Lime Down

Solar Park

Supporting Environmental Information Report (Change Application)

Document Reference: EXAM/9.41

- 1:2,500 @
-
- LIME DOWN SOLAR PARK**
Figure 3-4-5.1
Lime Down Solar Park - Site E Sheet 1
Landscape and Ecology Mitigation Plan - Revision 4
EN010168/APP/6.2
5(2)(a)

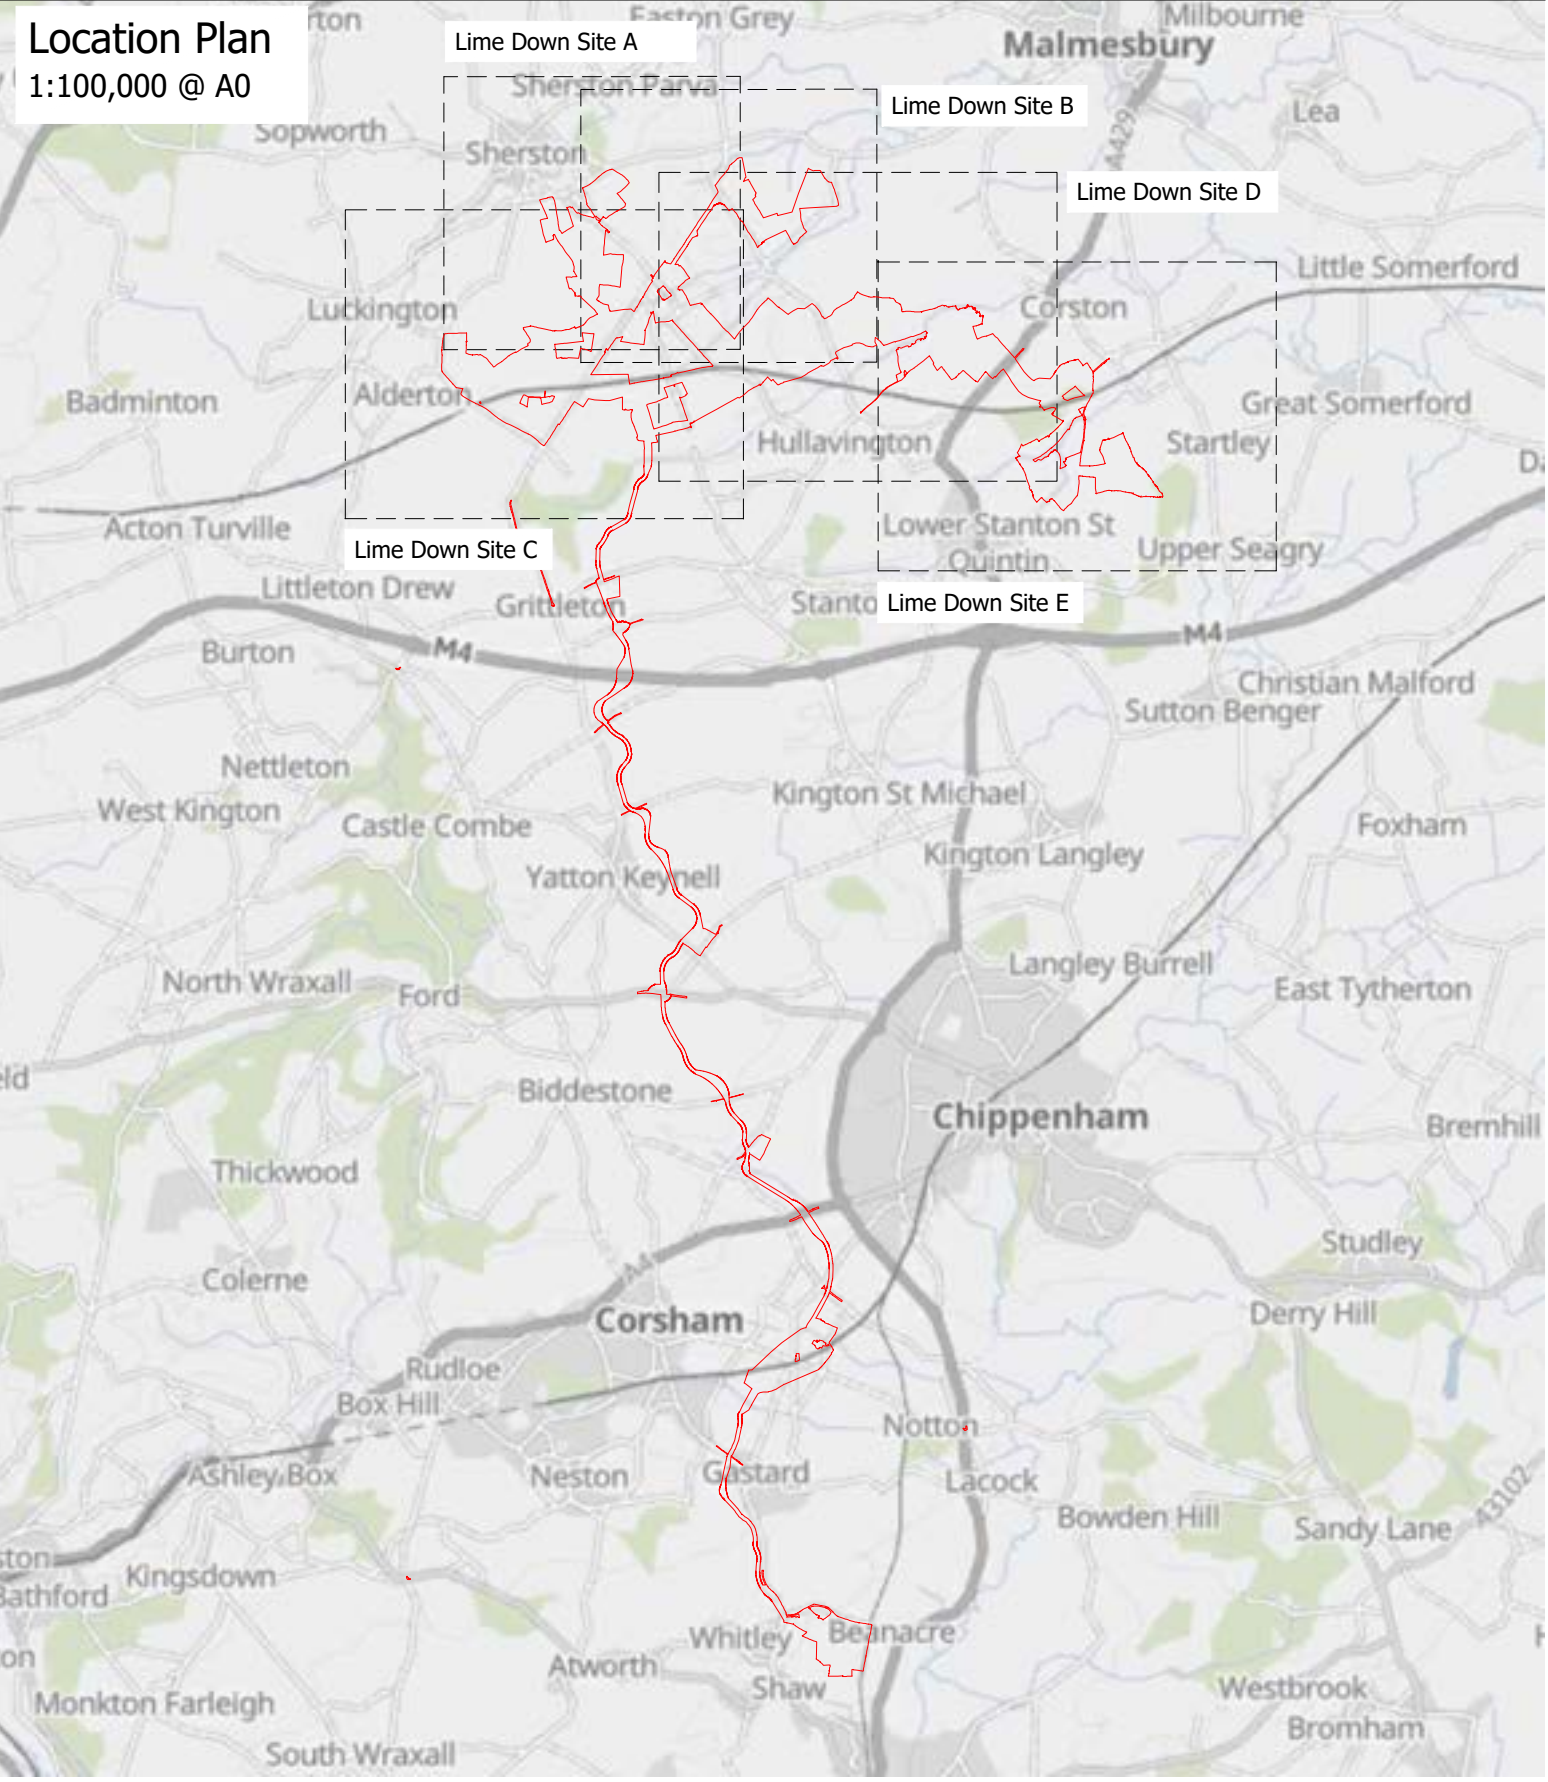
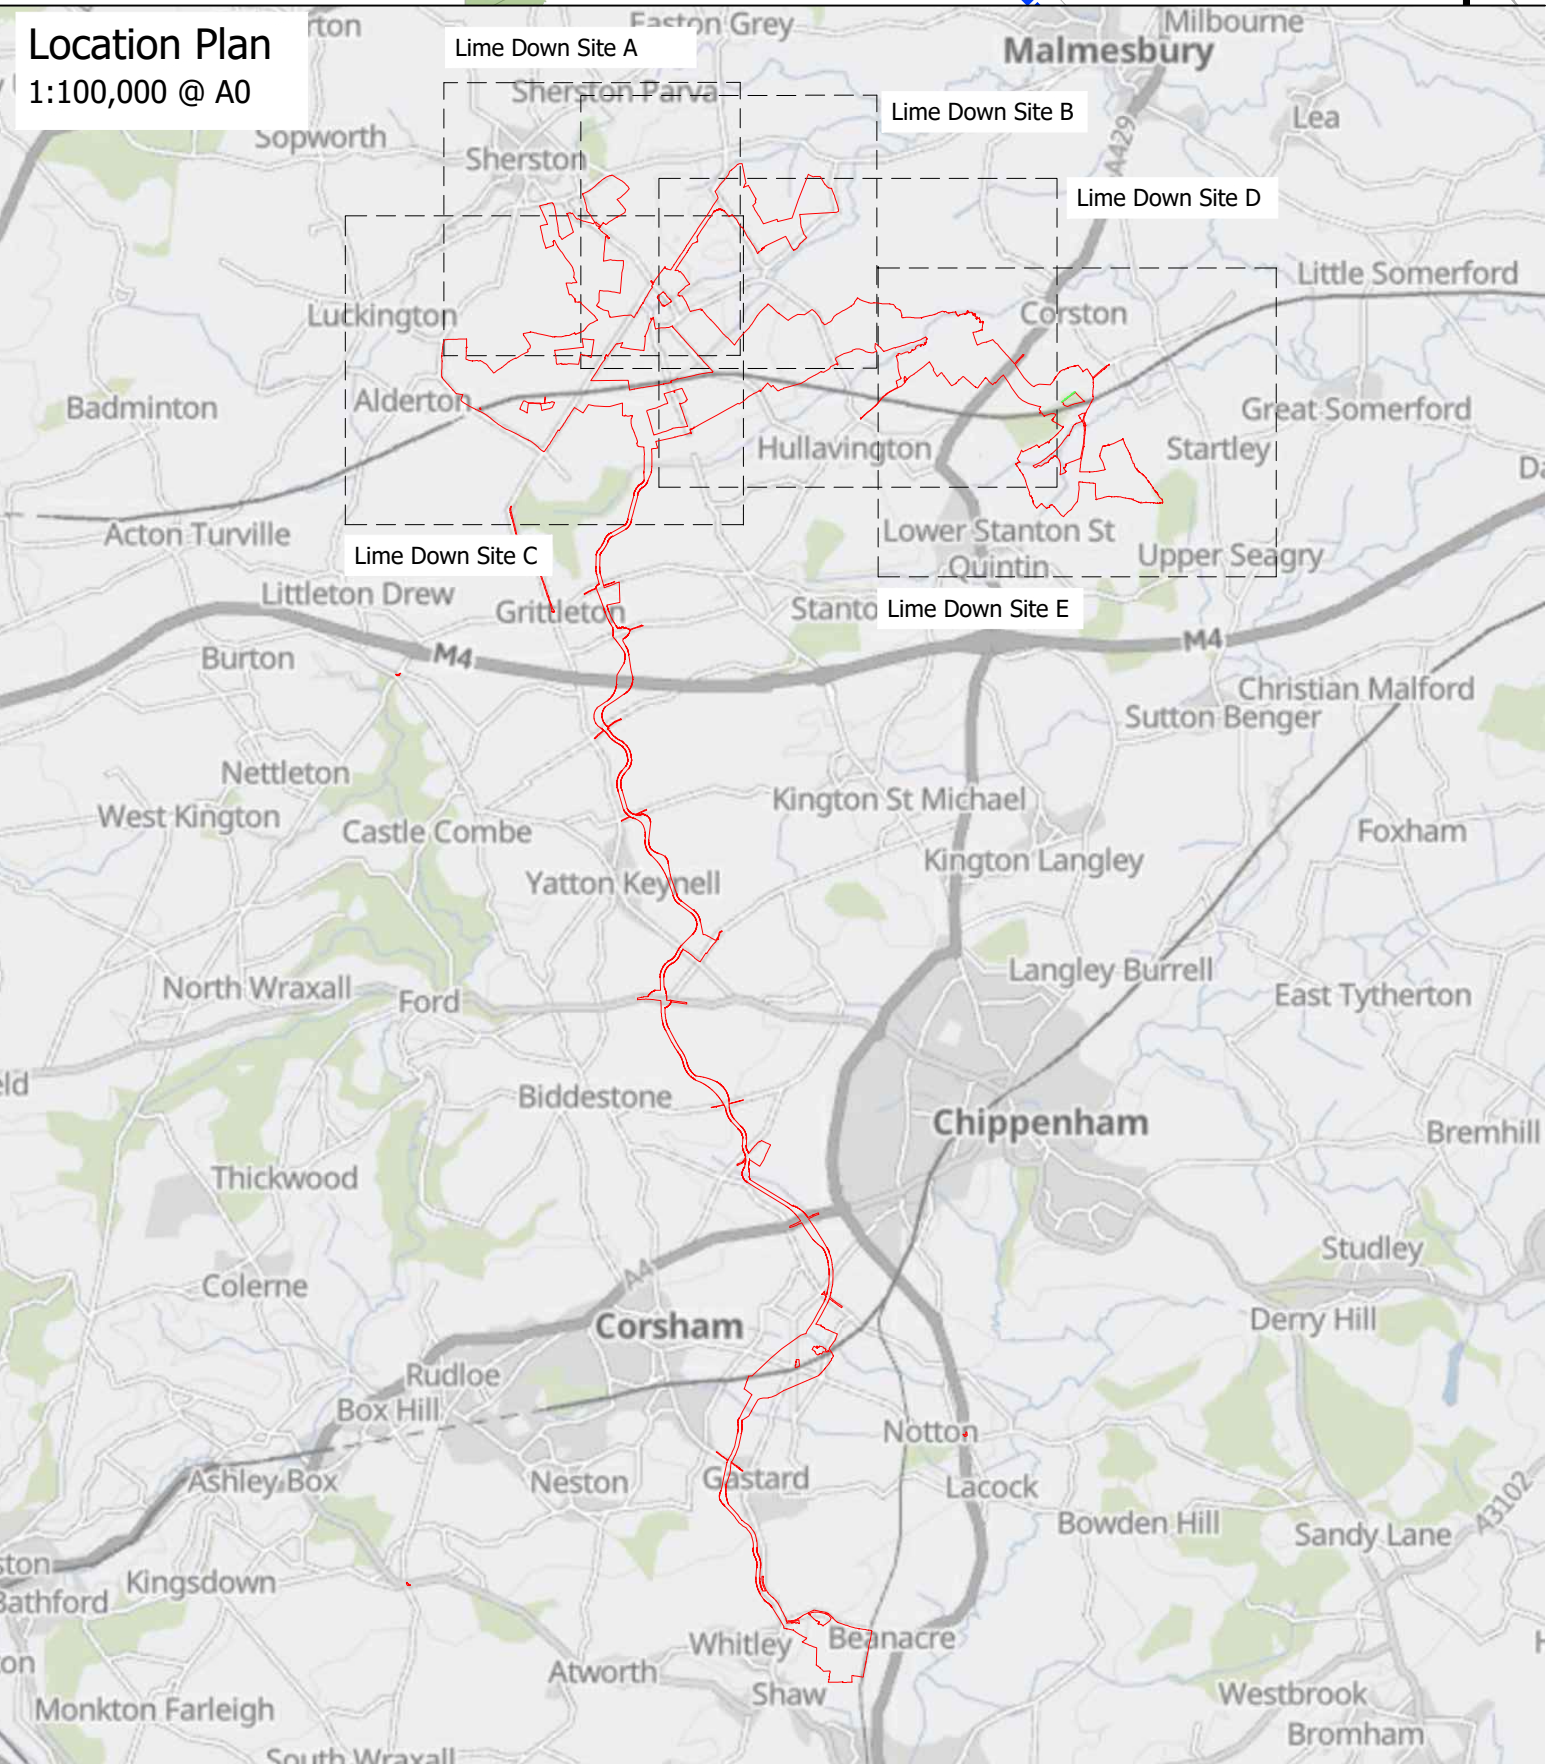
1.7.2 Hedgerow reinstatement within Field C9 would still be undertaken in accordance with **ES Volume 2, Figure 3-4-5.1 to 3-4-5.2 Landscape and Ecology Mitigation Plan (Rev 2) [REP1-032]**, along with low density scrub planting within the whole of Field C9.

- 1.10.10 The removal of Solar PV Infrastructure in Field C9 would still allow for hedgerows reinstatement within Field C9 in accordance with **ES Volume 2, Figure 3-4-5.1 to 3-4-5.2 Landscape and Ecology Mitigation Plan (Rev 2) [REP1-032]**, along with low density scrub planting of the whole Field C9, which is within the setting of the CNL. These positive enhancement measures are in keeping with the setting of the CNL. The updated **ES Volume 2, Figure 3-4-3.1 Landscape and Ecology Mitigation Plan, Lime Down C, Sheet 1 [REP1-030]** submitted with this Change Application illustrates the removal of panels from Field C9. Additional low density scrub planting would increase the amount of positive enhancement being proposed within the setting of the CNL and would provide an additional contribution to furthering the purposes of the designation.
